## ROCKY MT. CYCLE PLAZA

BUILDING ADDITION  
847 STRUTHERS RANCH RD.  
COLORADO SPRINGS, CO 80921  
EL PASO COUNTY, COLORADO

### RESUBMITTALS:

△	4-15-26/COMMENTS 2-4-26
△	
△	
△	
△	
△

1 of 7
SITE PLAN

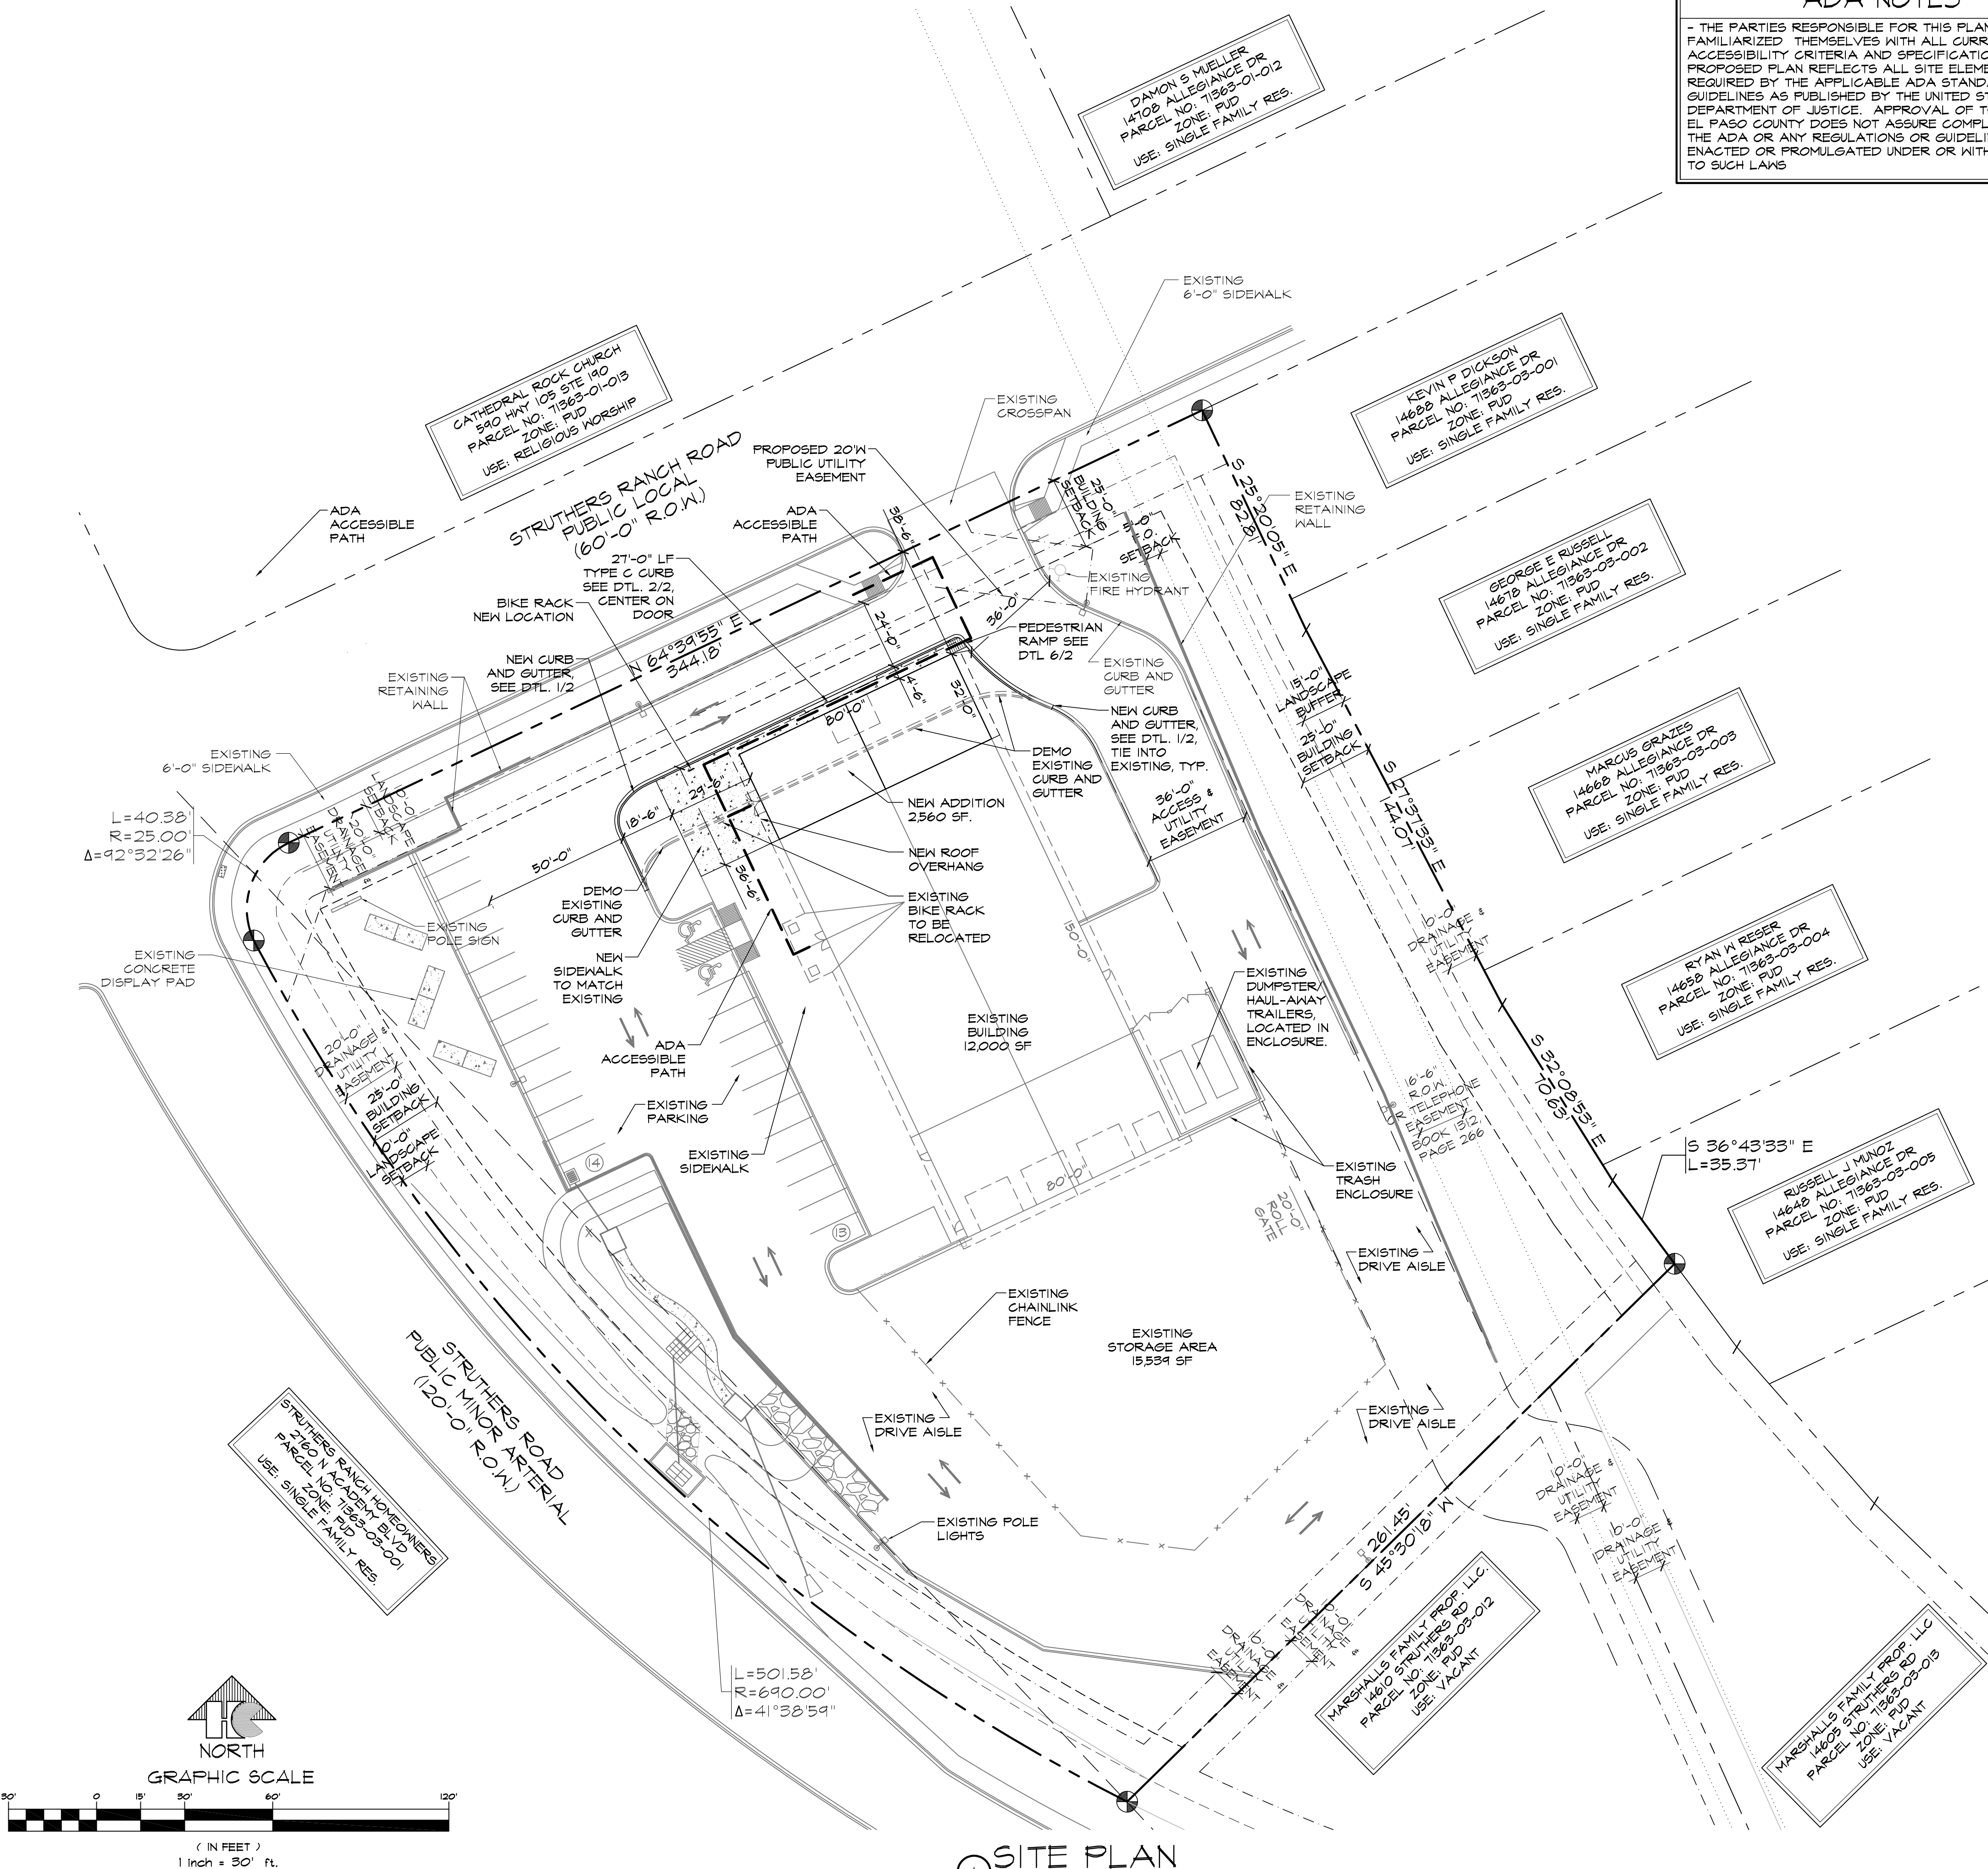
The PUD Development Guidelines identify the maximum building height in the commercial/office areas to be **40'-0" MAX**. See below. The approved PUD Development Guideline document can be found in EDARP.

13. Maximum building heights within the commercial / office areas shall be forty (40) feet or the maximum building height allowed within the USAFA height limitation requirements, which ever is lower. See PUD Development Guidelines Exhibit "B" Part 77 Surfaces for Aardvark Auxiliary Airfield. As illustrated in Exhibit "B", portions of Tract A, Filing 2 will not be able to achieve the maximum height of forty (40), feet. All submitted site development plans within the commercial / office areas shall include Part 77 surfaces height limitation calculations.

**FYI CODE REFERENCES FOR FUTURE SITE DEV PLAN SUBMITTAL: (Please review all Ch 6)**
